Rezoning Transportation Analysis

Petition Number: 2020-083

General Location Identifier: Tax ID 12703702

Date	Description
07-23-20	First Review

SCHEMATIC SITE PLAN

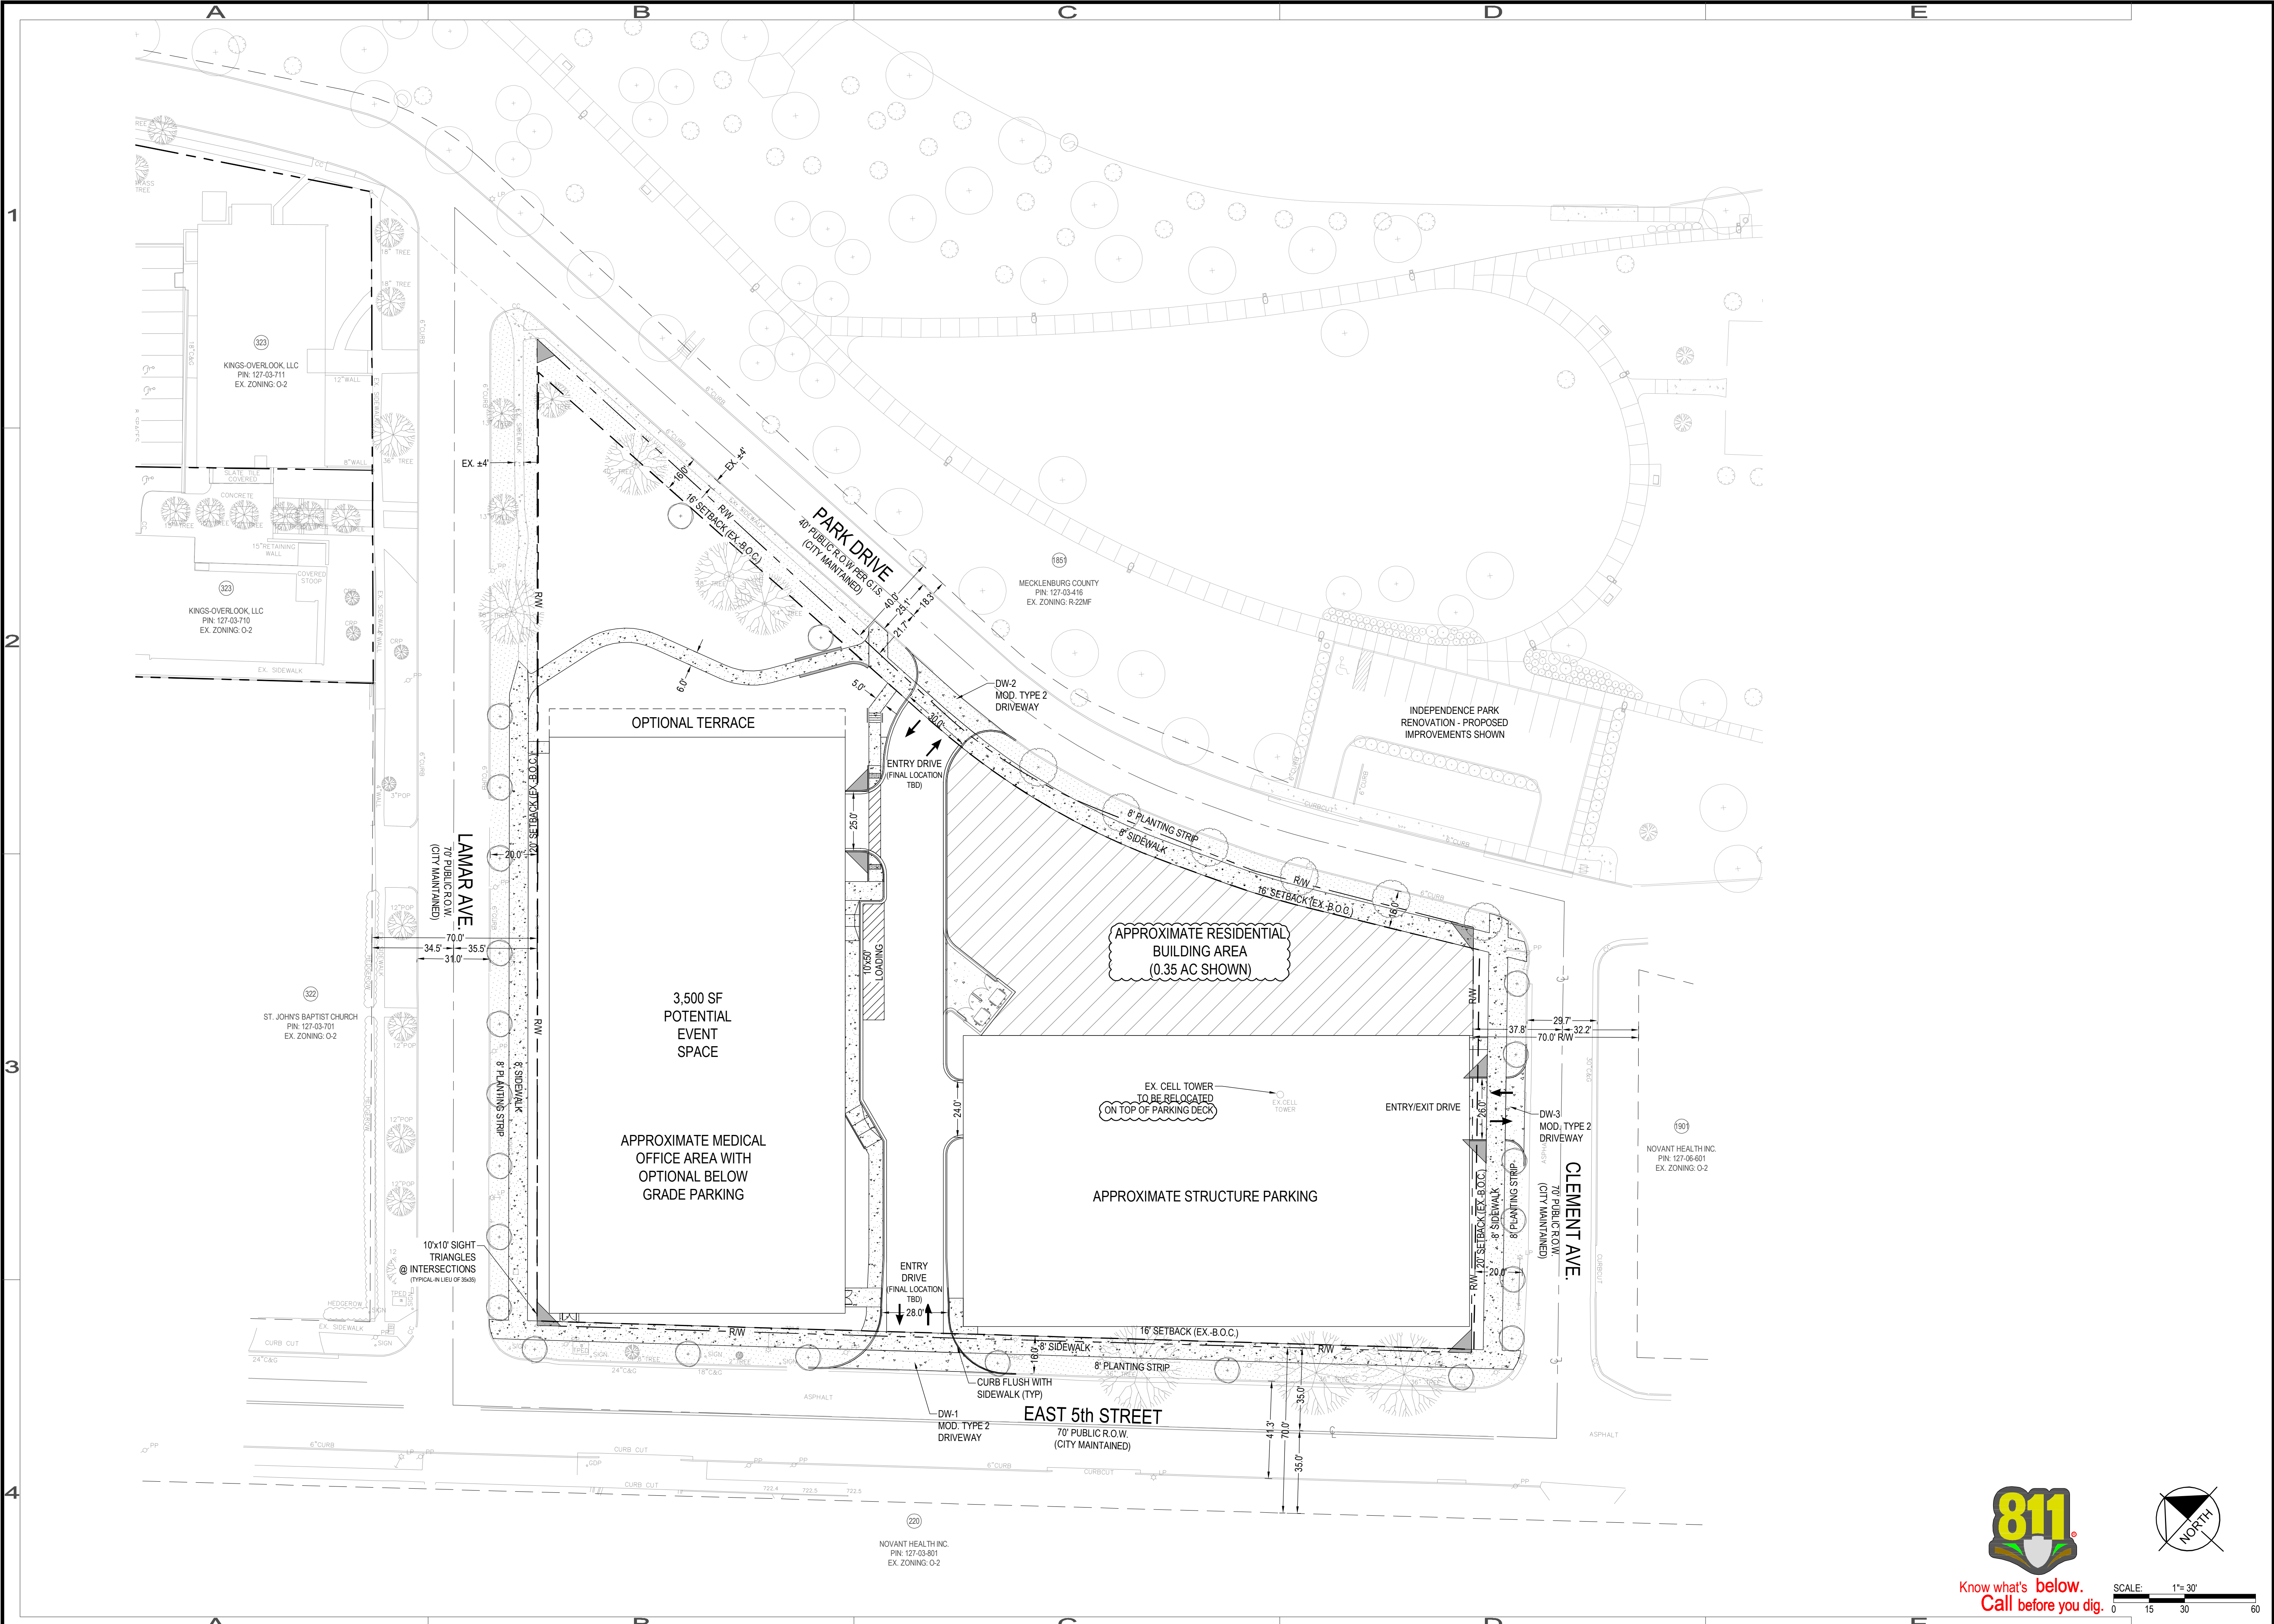
1. **Curblines** The proposed zoning district has a setback measured from back of the existing or proposed future curblines.

- a. The future location of curb and gutter is in its existing location for all abutting roads

The site plan should show the curb and gutter labeled and dimensioned from the centerline for each road.

3. The petitioner should revise the site plan to show the driveway further away from Clement Avenue — a minimum of 75' from the Clement Avenue.
4. The petitioner should revise the site plan to add a note specifying dedication and fee simple conveyance of all rights of way to the City before the site's first building certificate of occupancy is issued. CDOT requests right of way set at 2' behind back of sidewalk where feasible.
5. The petitioner should revise the site plan to add a note specifying all transportation improvements will be approved and constructed before the site's first building certificate of occupancy is issued. The petitioner may phase transportation improvements if said improvements and phasing are explicitly described in site plan notes.
6. **Resolved** ~~Sample format for comment that is resolved~~
